Project Name: * BR-0060

Subject: **Additional Information Response for the 401 Certification and Buffer Authorization** for the replacement of Bridge No. 14 located on NC 87 over Cane Creek, Alamance County
DWR# 20250885

Reference: On hold letter dated August 1, 2025 (DWR# 20250885)

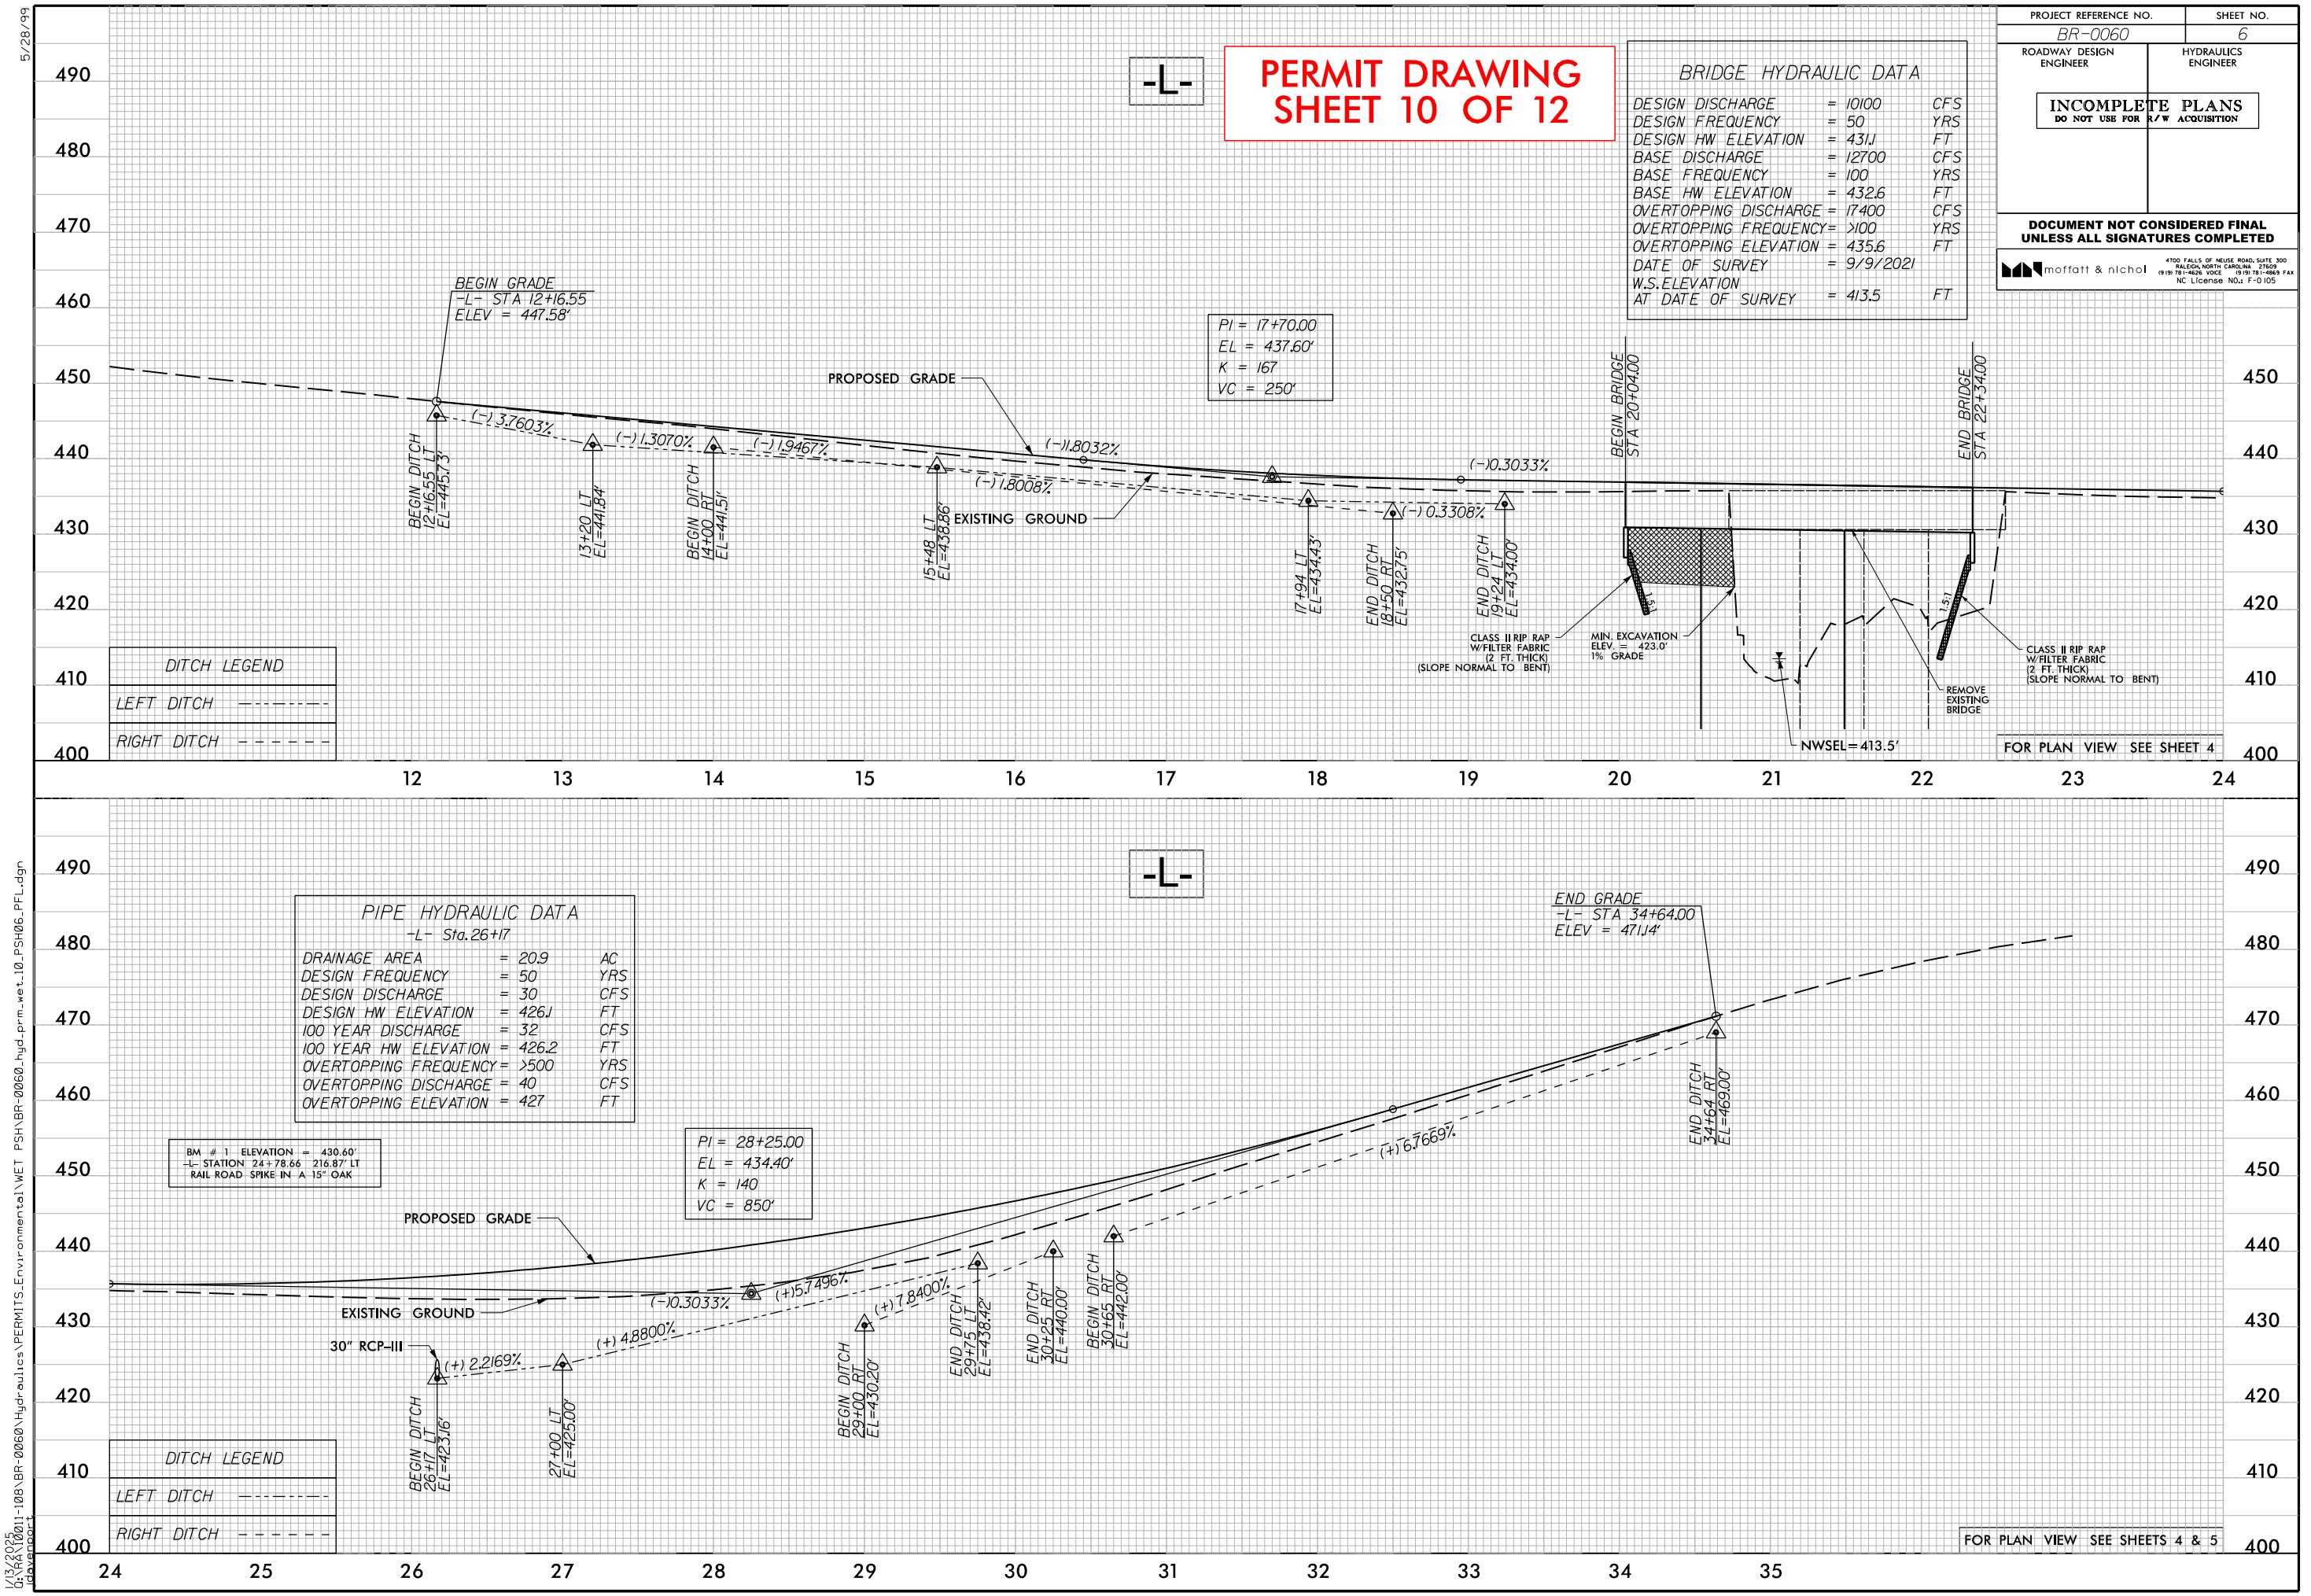
Confirm Sheet 5 of the Permit drawings. At the end of the Project and east of NC 87, there is an off-site pond which appears to drain into the Project area. Please provide supporting information and data forms collected in this area.

Please label stream SB and Stream SC throughout the permit and buffer drawings.

Stream SC does not appear to be depicted on the permit drawings.

During the site visit by our consultants, there was no drainage from the off-site pond to the study area identified. Therefore, no forms were completed. Also, Location & Survey did not pick up a drainage feature from the off-site pond to the study area. It appears that any drainage from the off-site pond flows to the roadside ditch (see attached photo of the drainage area. The [link below](#) directs to this particular area, between the off-site pond and drainage roadside ditch on Google Maps).

It appears that the feature identified in the CE Document Figure as Stream SC (labeled on the attached Figure as Ditch DA) may be a relic drainage feature from the off-site pond to Cane Creek. However, it is no longer an active conveyance from the off-site pond (see Stream ID Form for Ditch DA; score = 10.5). See Response to DWR Comment 4 for additional information.

The non-JS blue line feature (SB) has been labeled on the permit and buffer drawings.

As described in the Response to DWR Comment 2, Stream SC has been updated to/labelled as Ditch DA (in attachment) and a label has been included on permit and buffer drawings.

Stream SC was determined to be ephemeral (score = 10.5), and therefore not included in the permit and buffer drawings. As noted in prior responses, Stream SC is re-labeled as Ditch DA (SC => Ditch DA) on the Figure *Potential Jurisdictional Features Map* in the attachment.
